Your ref: CONCP/3/2007/0964
 Our ref: SPT/MK/PWAB/05/07/0964 (CM)

Date	2 November 2007
FILE	
DOF	
FSM	
- 6 NOV 2007	
REC'D	
AD	
ENV	
COM/TER	
RE/RES	
OTHER

PLANNING APPLICATION NO 3/2007/0964
PROPOSED B1 OFFICE DEVELOPMENT (8746 SQ M) REVISION TO
APPROVED MATTERS APPLICATION
BARROW BROOK BUSINESS PARK BARROW LANCASHIRE BB7 9WA

Schematic Layout 5

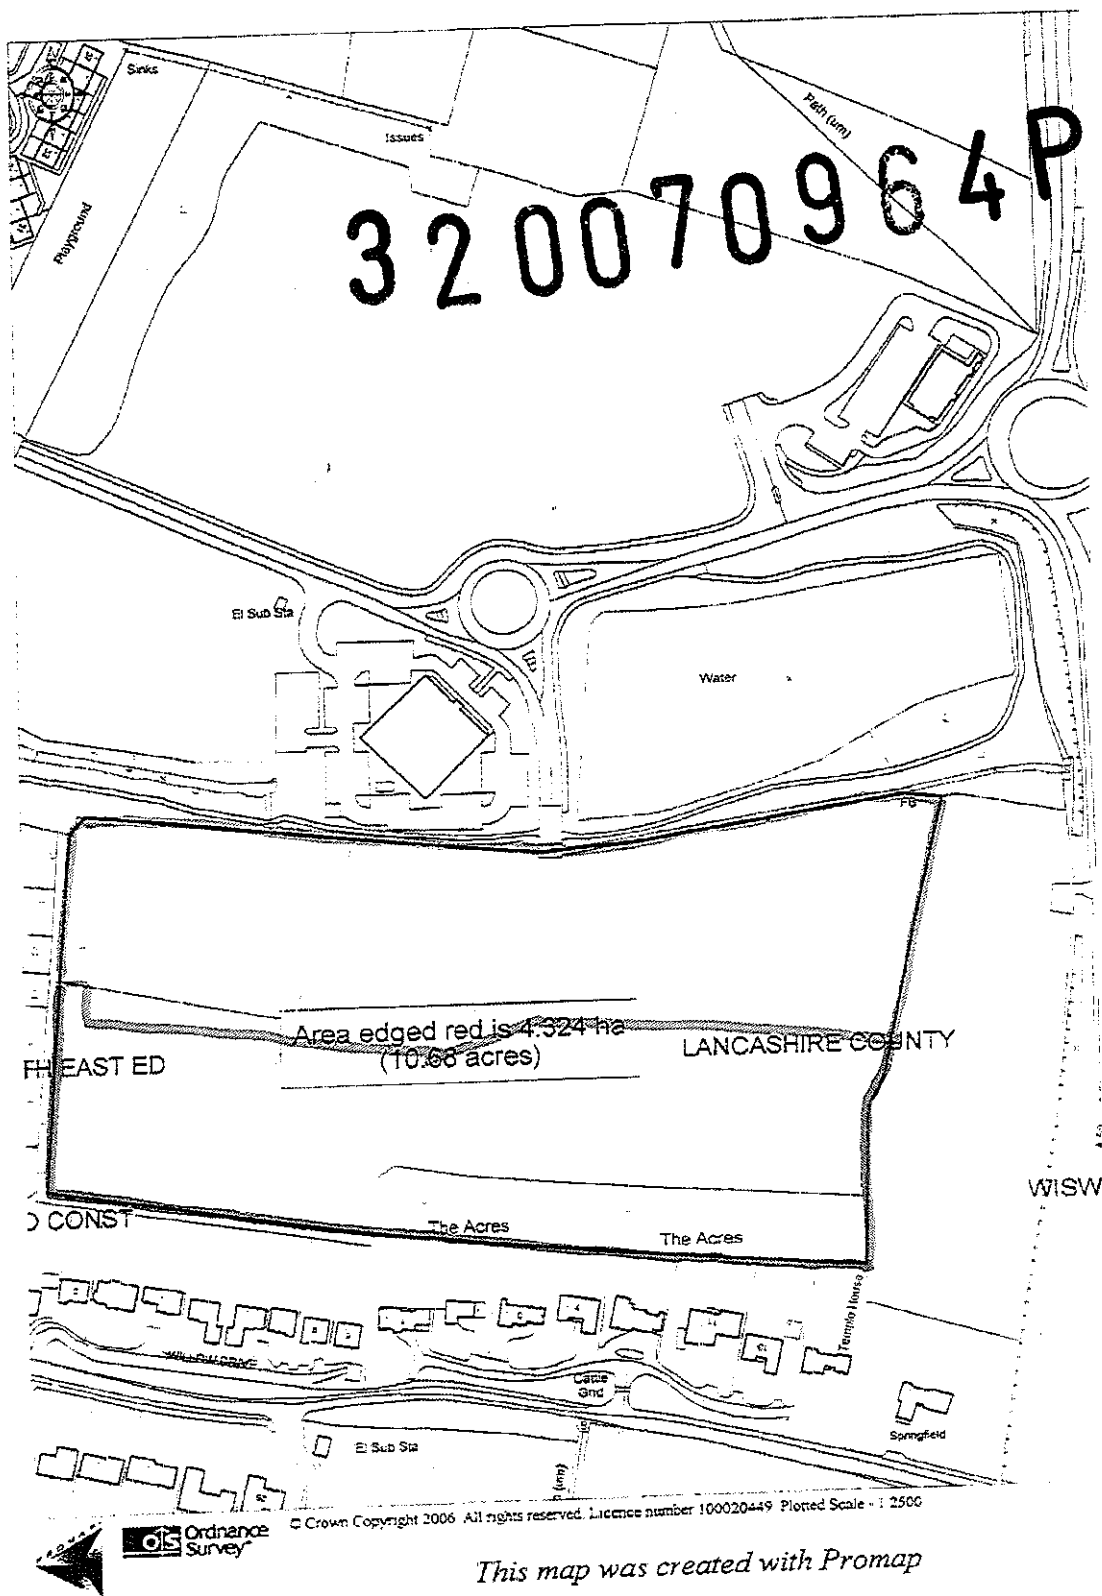
Policy 7 of the JLSP requires that parking provision for new development will meet the standards set out in the adopted JLSP Parking Standards. The proposed development has a low accessibility score. The standard for B1 office is 1 car parking space per 35 square metres gross floorspace. Application of this standard would result in a total of 250 car parking spaces for the proposed development. The application form states that 331 car parking spaces would be provided, which would be 81 car parking spaces more than the provision required by the parking

standards. This would be contrary to the JLSP Parking Standards. As no justification for this overprovision is provided, the amount of car parking proposed should be reduced to accord with the Parking Standards.

The SPG requires "*No net loss of hedgerows through development*" for the Undulating Lowland Farmland landscape. It is not clear from the submitted drawing (ref. *Scheme Layout*) whether there would be a net loss, since the graphic symbols used are not supported by a key or legend. Existing hedgerows, trees and scrub should be incorporated in the proposals and could form the basis of a landscape structure within the site.

I am concerned that any existing trees and shrubs in the vicinity of the southern boundary may be adversely affected by construction and provision of the proposed roads and car parking (again, the extent of this is not clearly shown on the Scheme Layout plan). Retention of the existing planting along this boundary is essential as the adjacent residential properties are probably the most sensitive visual receptors in the area.

An appropriate separation distance/buffer between the proposed development and the adjacent watercourse is required. As proposed some of the buildings would be less than 5 metres from the edge of the watercourse. Given the potential importance of the watercourse for wildlife, and the possibility of the presence of protected species such as water voles, I recommend that landscape proposals along this boundary be developed with the assistance of an ecologist.
